**EL PASO COUNTY PLANNING AND
 COMMUNITY DEVELOPMENT
 DEPARTMENT**

GRADING AND EROSION CONTROL PLAN CHECKLIST

Revised: July 2019

GRADING & EROSION CONTROL PLAN
CLAREMONT BUSINESS PARK 2 FIL. NO. 1 - LOT 5
JOB NO. 44-037
DATE PREPARED: JULY 17, 2020
DATE REVISED: OCT 27, 2020

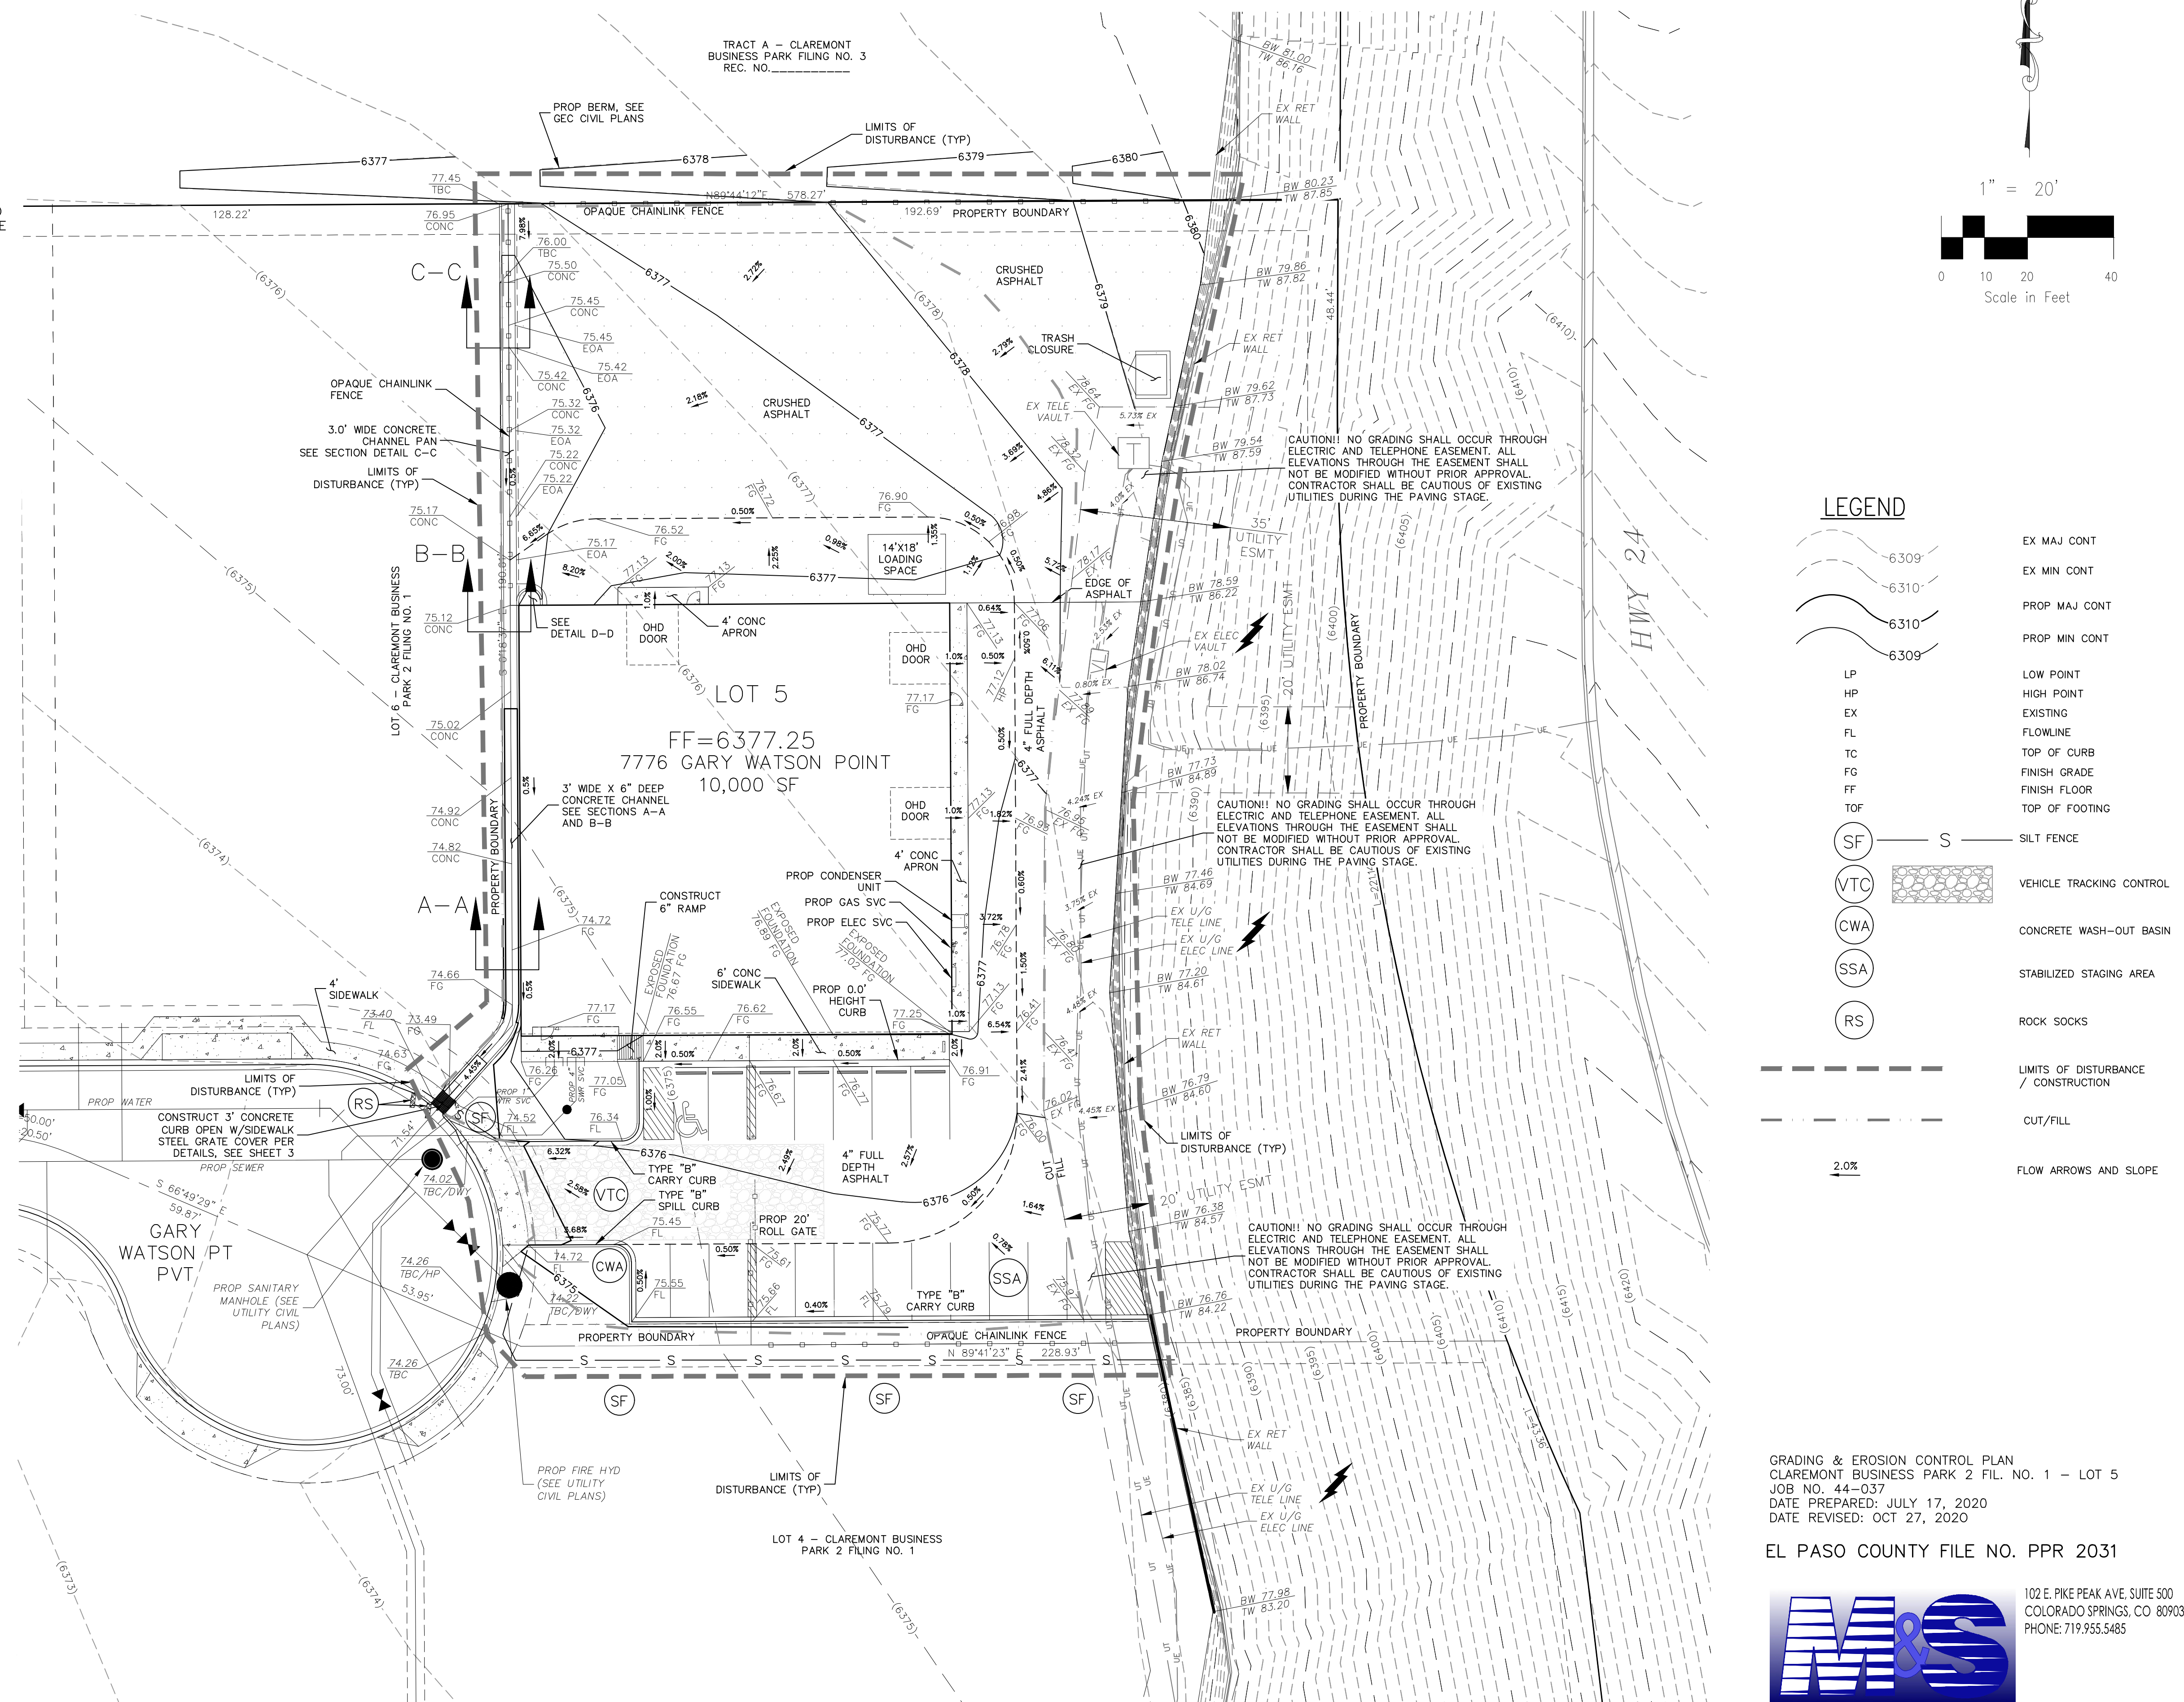
Applicant	PCD
1. GRADING AND EROSION CONTROL PLAN			
a	Vicinity map.	X	✓
b	Adjacent city/town/jurisdictional boundaries, subdivision names, and property parcel numbers labeled.	X	✓
c	North arrow and acceptable scale (1"=20' to 1"=100').	X	✓
d	Legend for all symbols used in the plan. Add drainage flow arrows to Legend	X	X
e	Existing and proposed property lines. Proposed subdivision boundary for subdivision projects.	X	✓
f	All existing structures.	X	✓
g	All existing utilities.	X	✓
h	Construction site boundaries.	X	X
i	Existing vegetation (notes are acceptable in cases where there is no notable vegetation, only grasses/weeds, or site has already been stripped).	X	X
j	FEMA 100-yr floodplain.	N/A	N/A
k	Existing and proposed water courses including springs, streams, wetlands, detention ponds, stormwater quality structures, roadside ditches, irrigation ditches and other water surfaces. Show maintenance of pre-existing vegetation within 50 feet of a receiving water.	N/A	N/A
